Agency Review Comments

Falcon Highlands Fil 3 PUDSP

PUDSP225

FILE LOCATION: S:\21.1208.001\FALCON HIGHLANDS\100 DWG\104 PLAN SETS\DEVELOPMENT PLANS\SP01.DWG

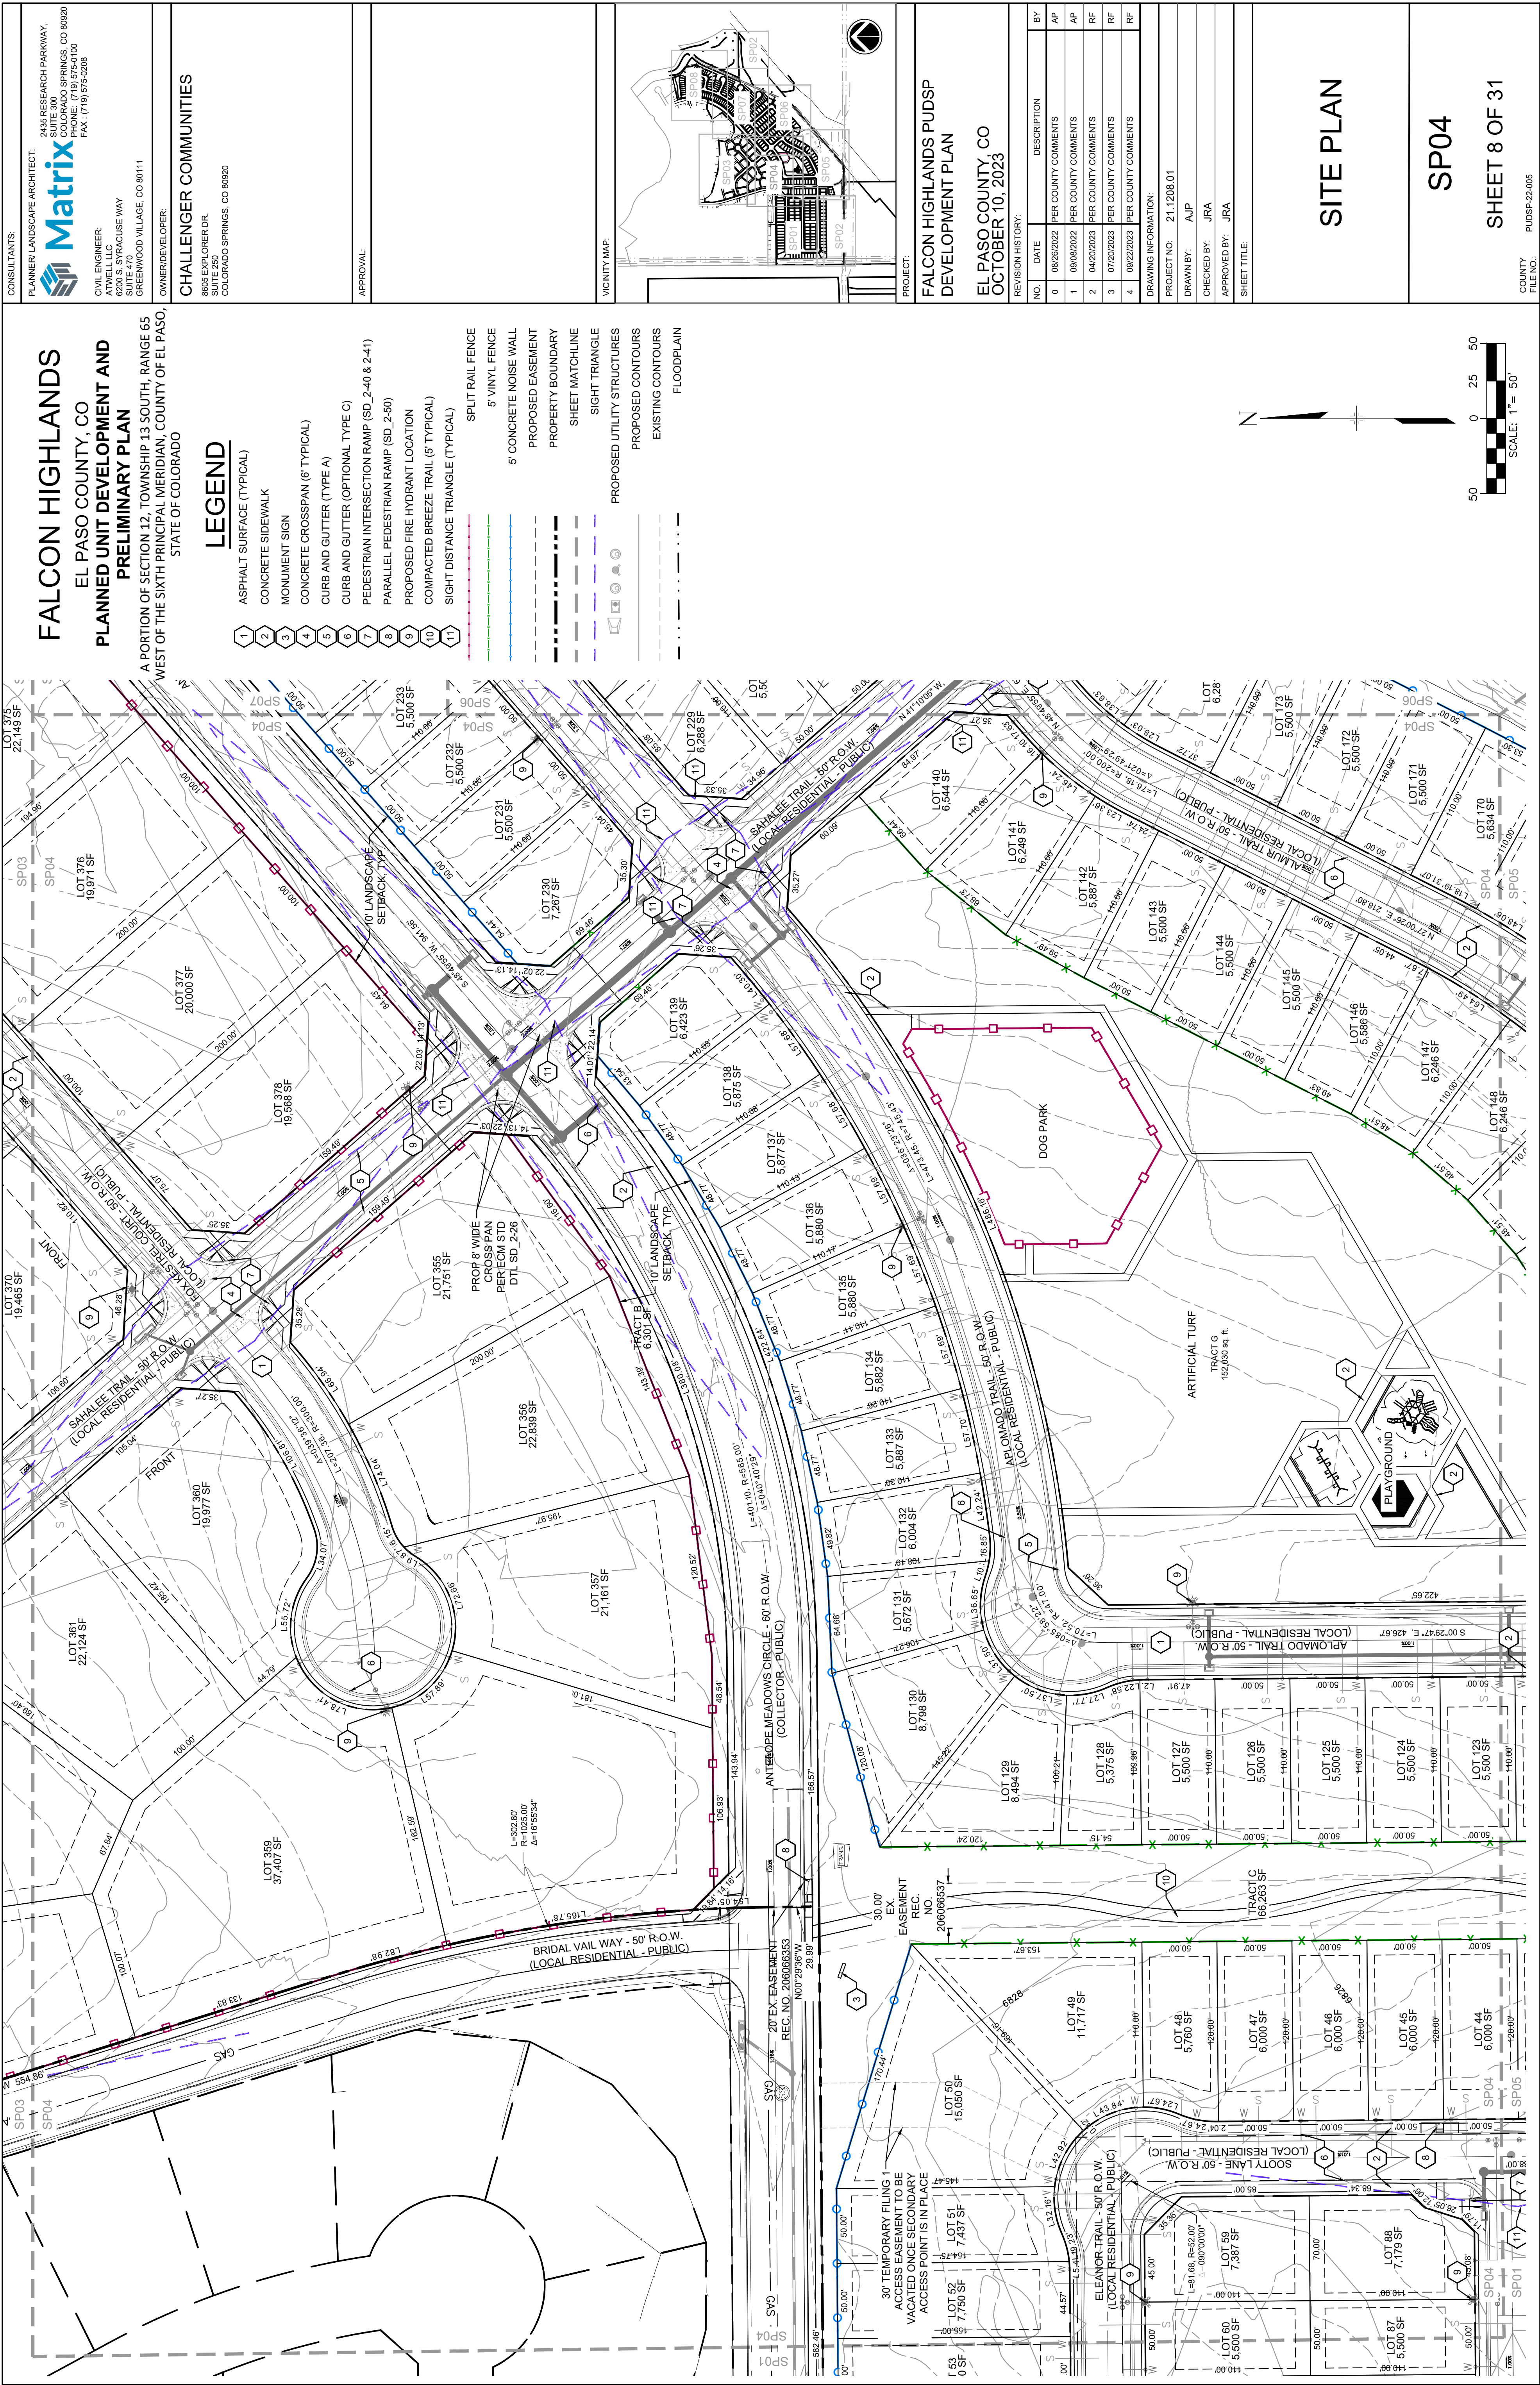
911 Authority - El Paso/Teller County	Streetnames previously approved. Please note: There are a couple of inconsistencies on the plan drawings submitted. - Lanner Ln is incorrectly labeled as Lanner Rod on Pg 5 and Pg 24 - Pg 20 still depicts Pied Harrier Loop instead of Birch Hollow Way looping through.	6/13/2022 8:50:30 AM
---	--	----------------------------

Corrected

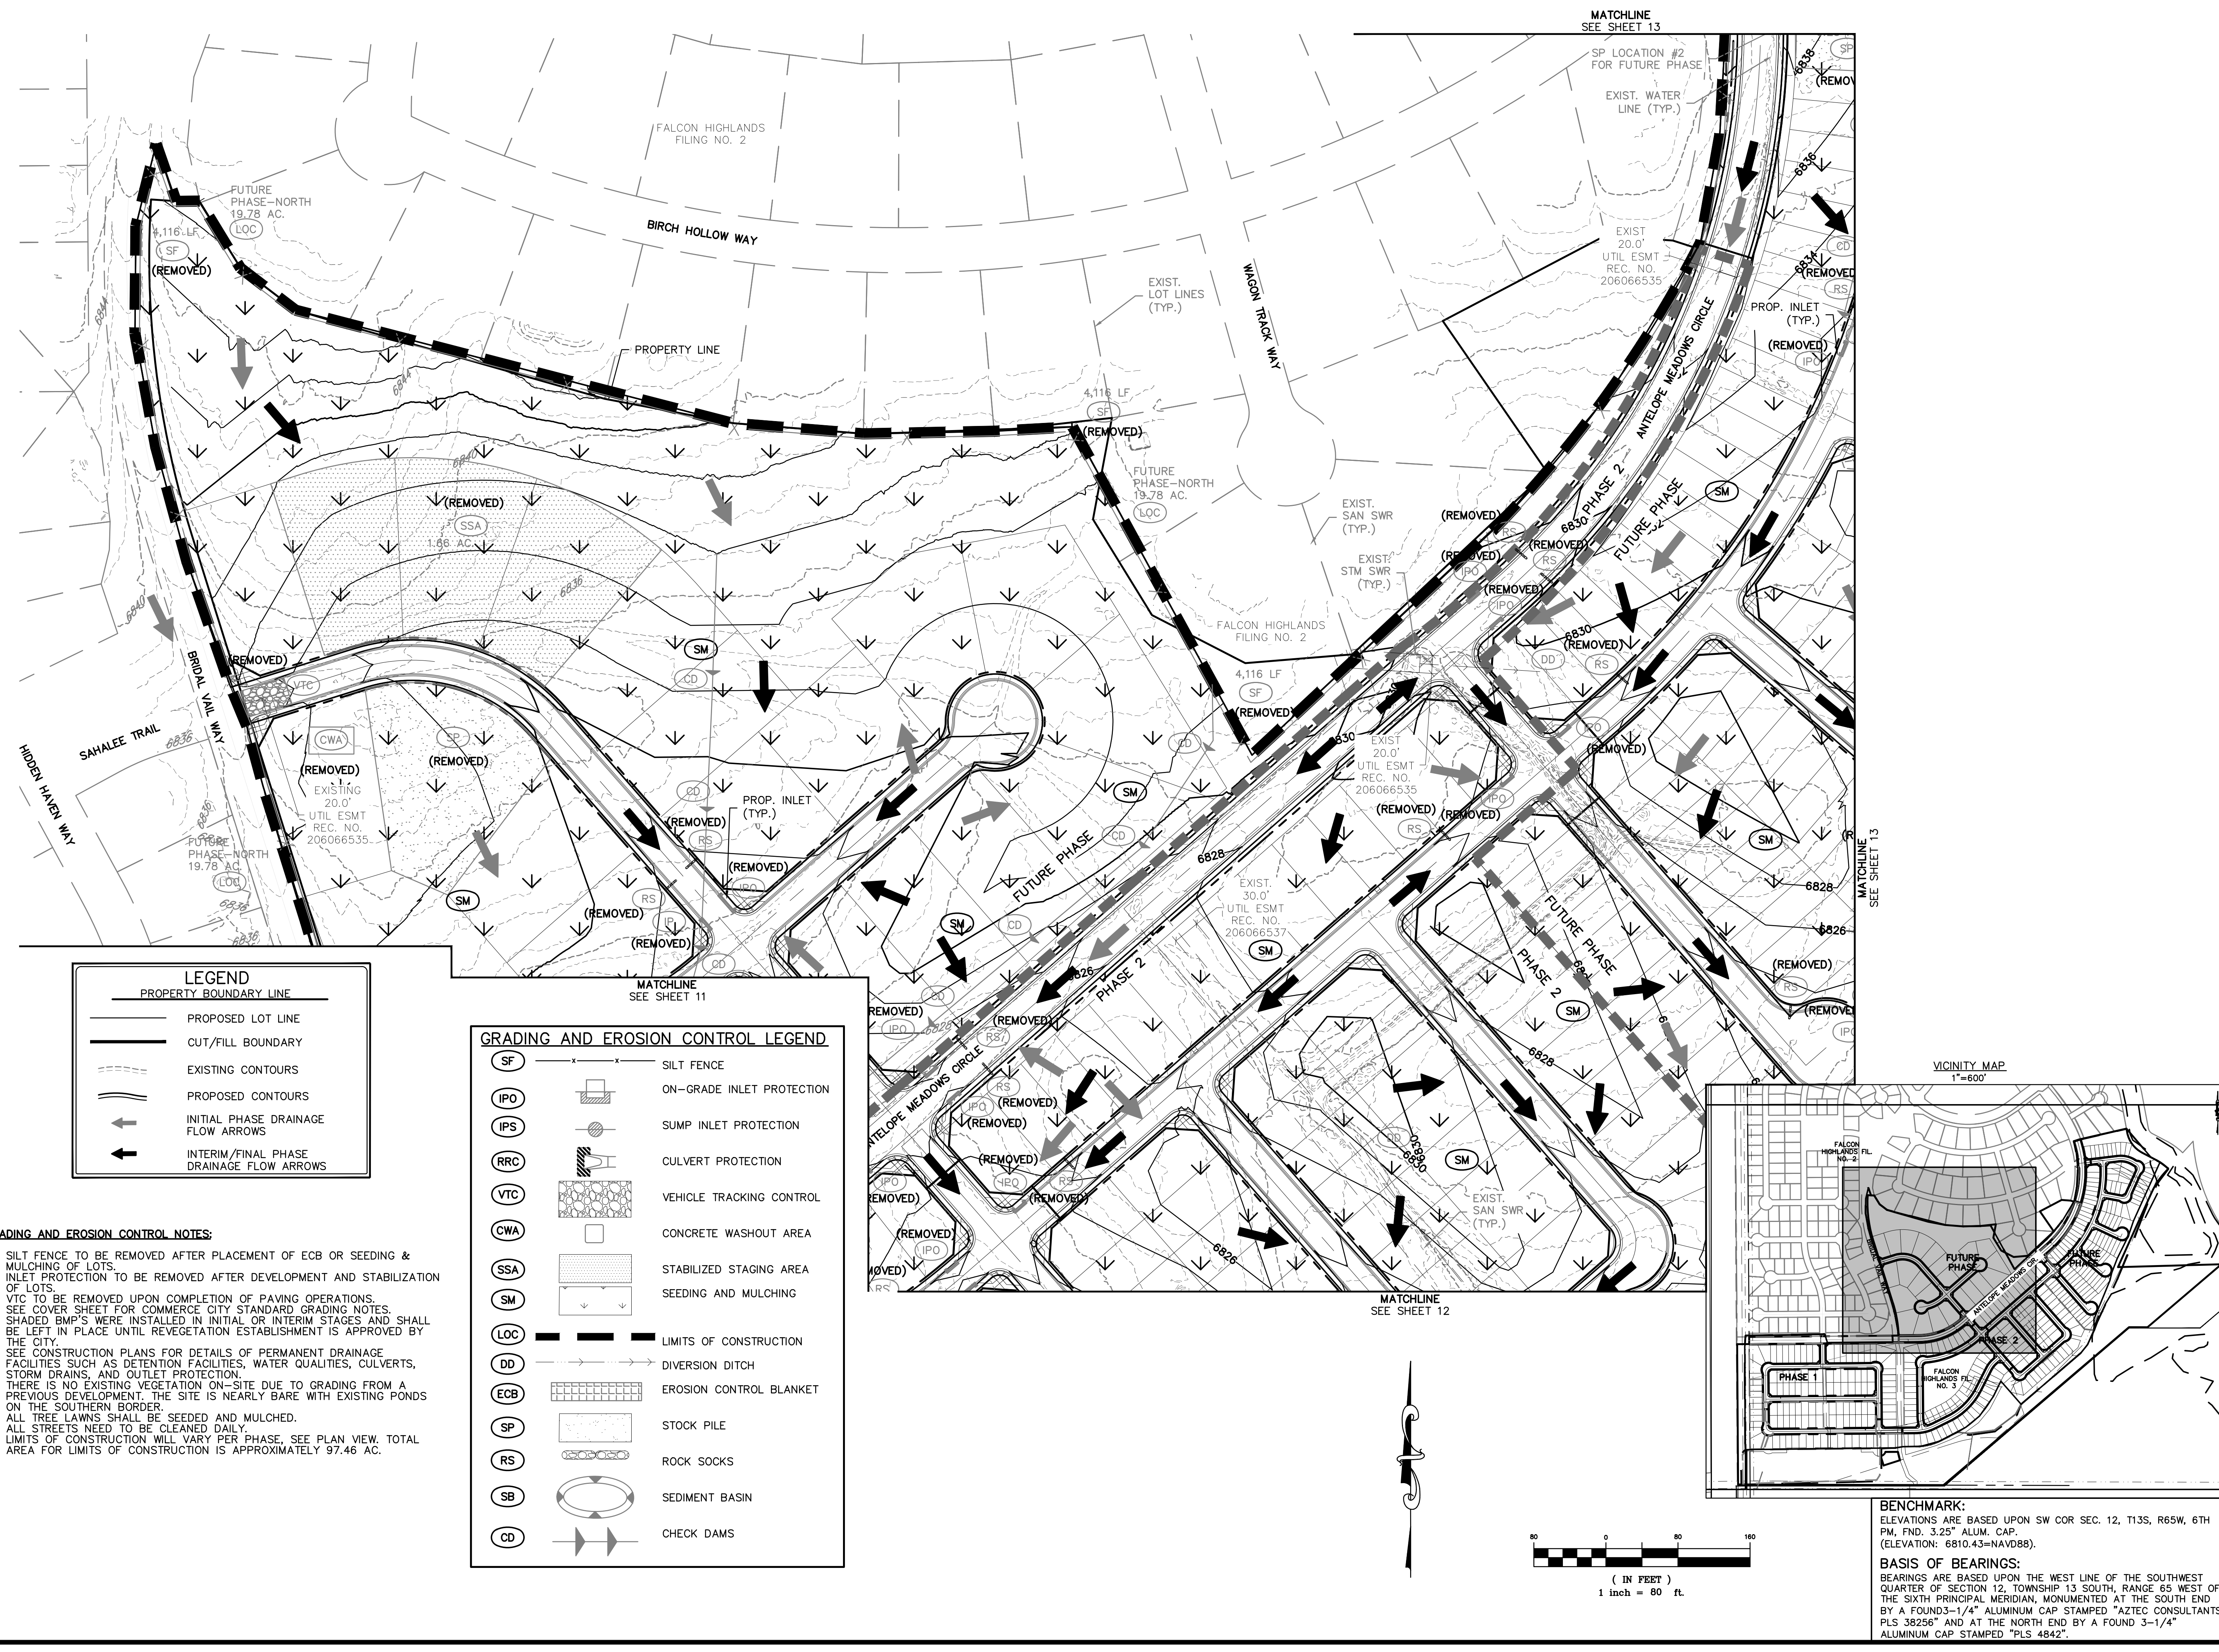
RBD Floodplain	lots 309,310, and 311 are shown within the floodplain. These will need to be removed from the floodplain prior to platting or removed as buildable lot's and combined into Tract J	6/8/2022 9:13:22 AM
-------------------	--	---------------------------

Lots have been removed
